To The Case Officer
Mr Sam Dicocco and
Mr Colin Haigh Head of Planning
Welwyn Hatfield Borough Council
The Campus
Welwyn Garden City
Hertfordshire AL8 6AE

2nd March 2017

RE: Objection to Amendments to Application by Mr & Mrs Anklesaria. - Ref:6/2016/1855/VAR Proposal to Removal of Condition 2 - Revised Plan drawings dated 17th January 2017)

Side Elevation (South facing) Proposed

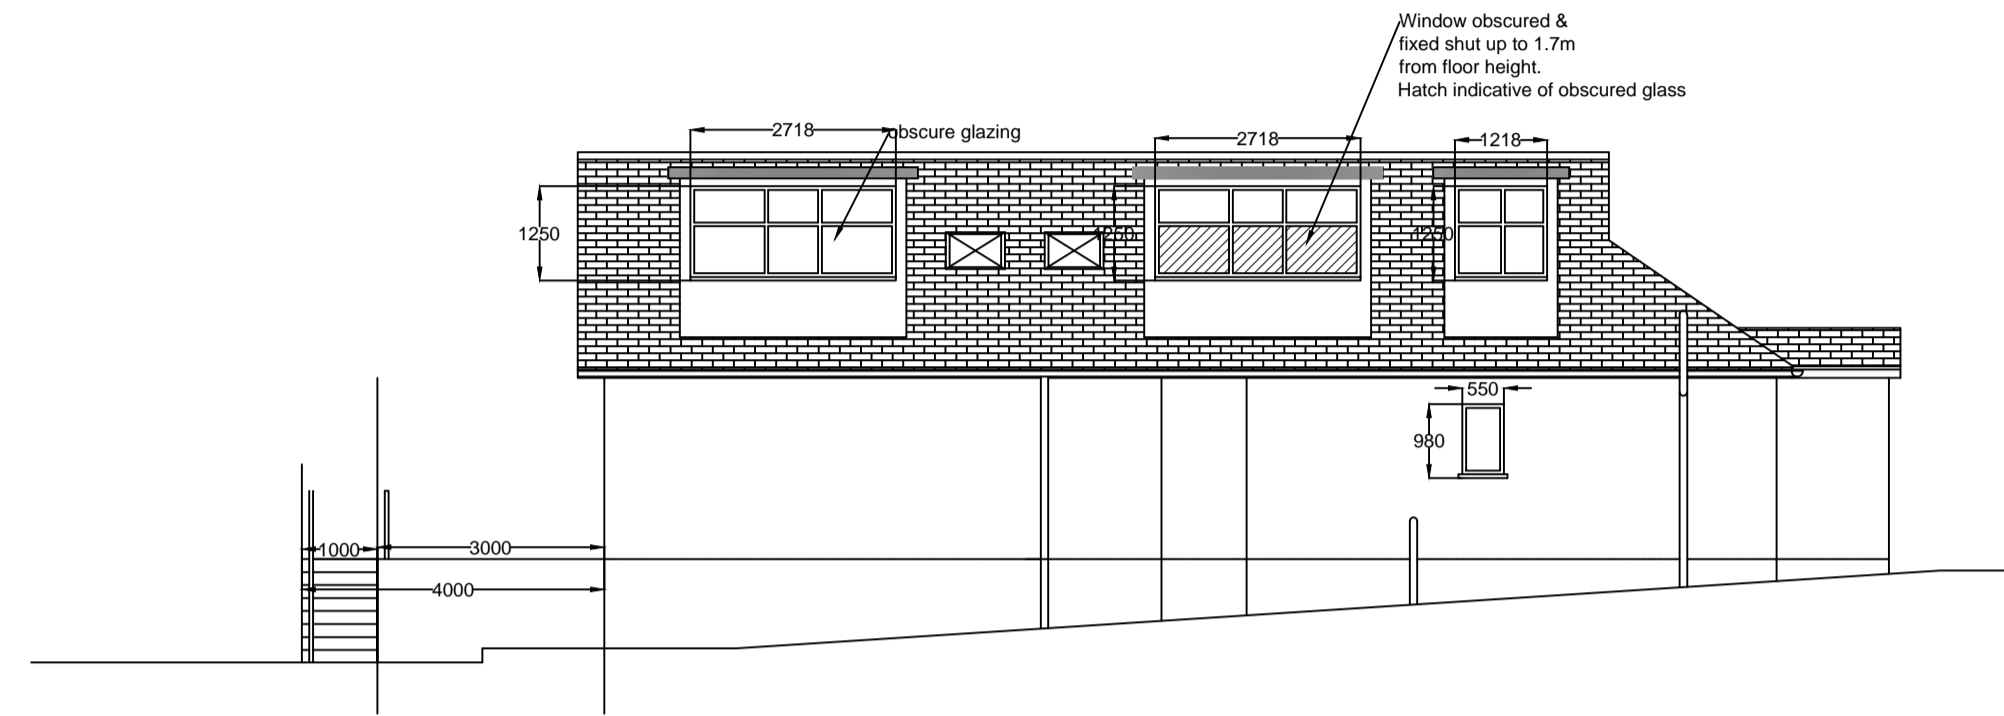
The Middle Dormer facing No.43 has four separate windows and not three as shown on the drawing. We have drawn the Council's attention to this breach of planning approval besides other blatant breaches.

The drawings of the South Facing Elevation facing our property at No.43 in respect of these Elevations are misleading. Our property at No. 43 is North facing. The Council originally had to amend their report at the DMC Committee meeting of 18th August 2016, when this issue of elevations was considered.

Window restriction Image not to scale

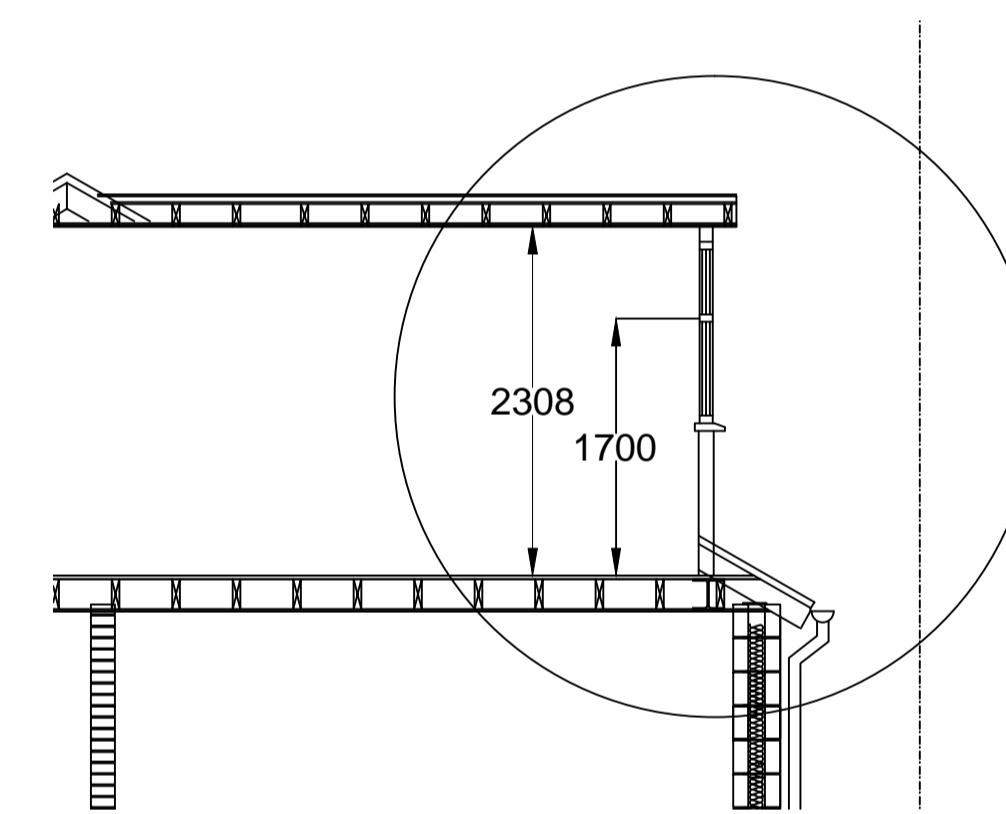
Partial opening of the windows is not acceptable as future adjustments to the range of opening can be made by the present and future owners of No. 45 to open the windows in their entirety. Allowing any opening of the windows would destroy: (i) our right to Human Right to Privacy; and (ii) would render the obscuring of the window glass pointless. **Restricting the window opening is just as important as obscuring the glass.** The Council should enforce the decision of the committee immediately and avoid further Applications.

North Facing Elevation windows

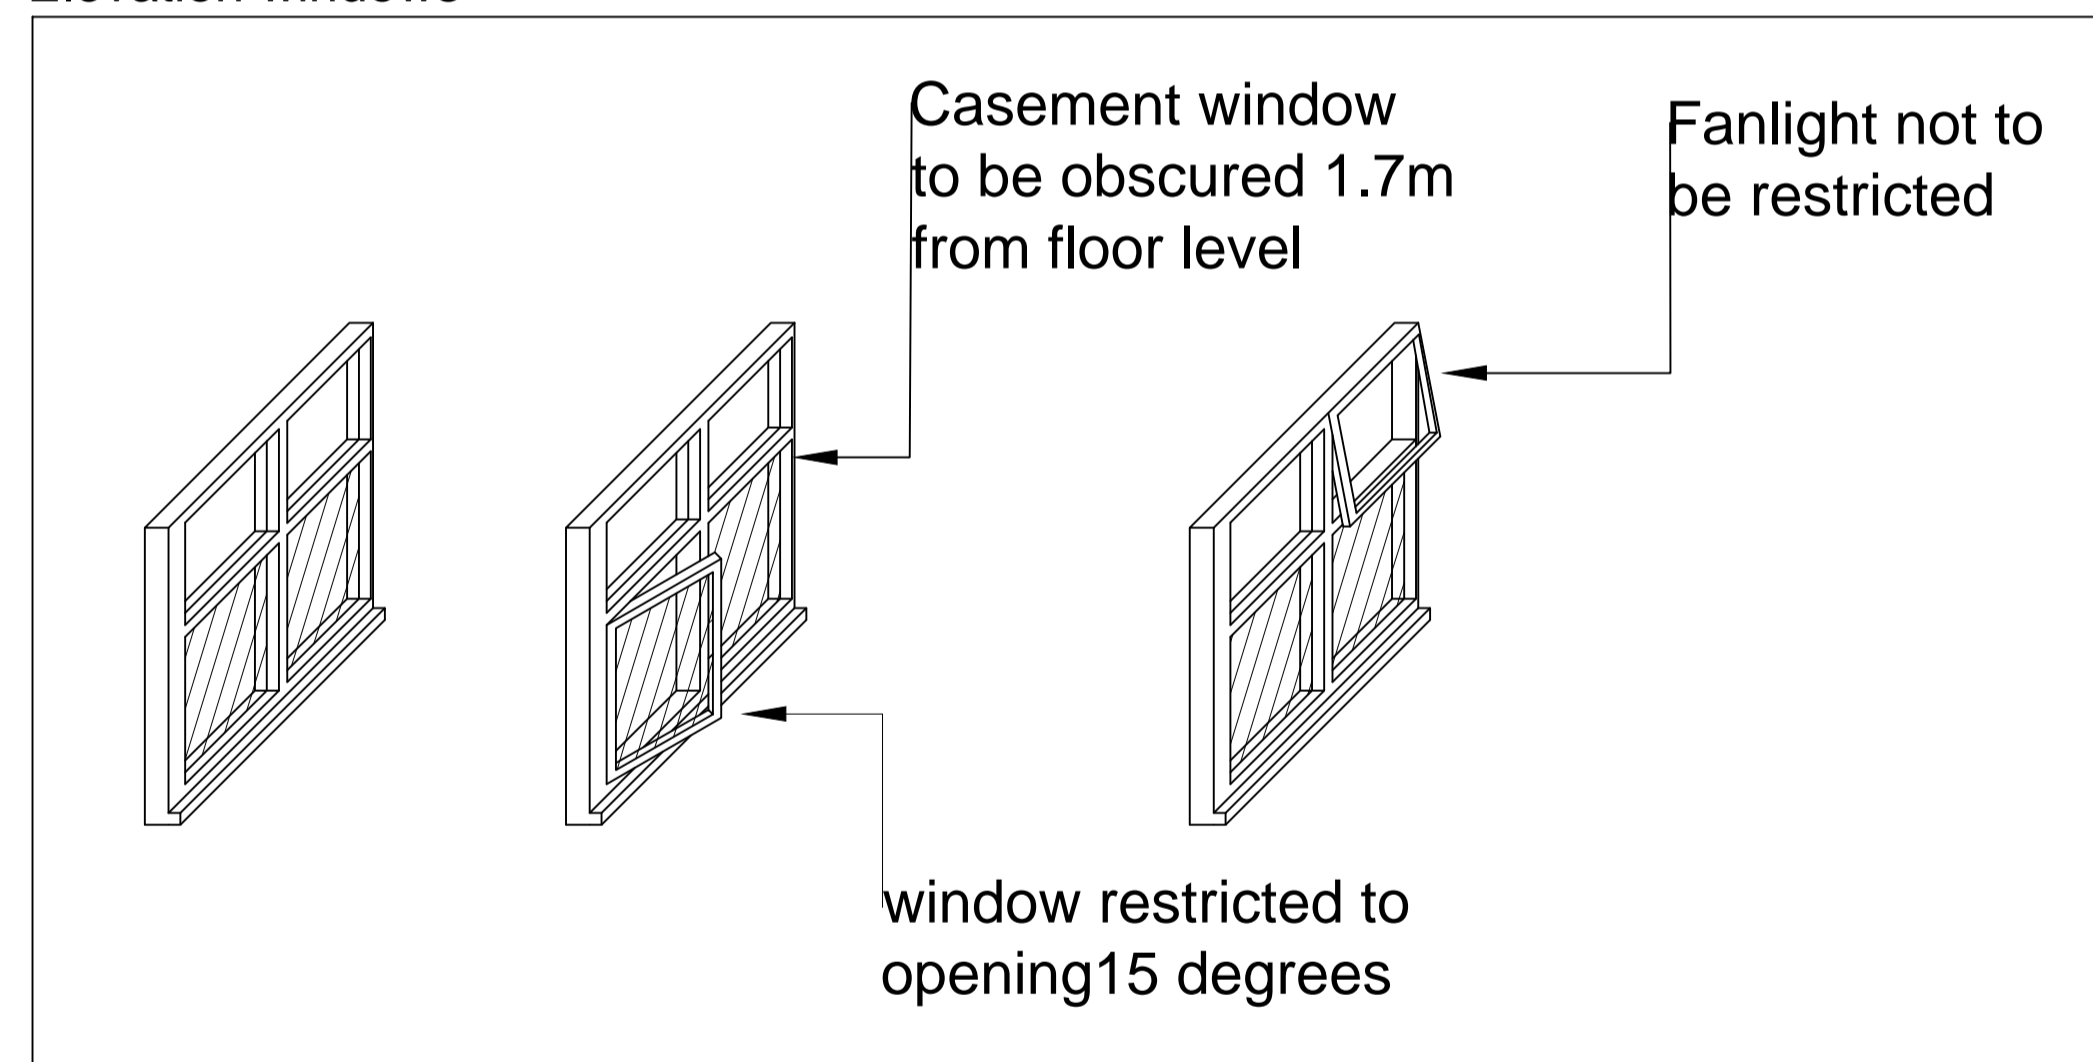
For the reasons stated above, we object the proposed Amendments to have partially glazed Dormer Windows facing our property at No. 43. Fixed obscured glass glazing is essential to protect our privacy, amenity and enjoyment of our property. The Council's decision on 18 August should be final.

All windows must be obscured in their entirety, partial obscuring up to 175cm for certain windows is not enough. **At 175cm from the floor a person 5ft 10" and above can easily look through** the non-obscured section. It is not an appropriate solution and any variation to the Committee's decision on 18 August is not acceptable.
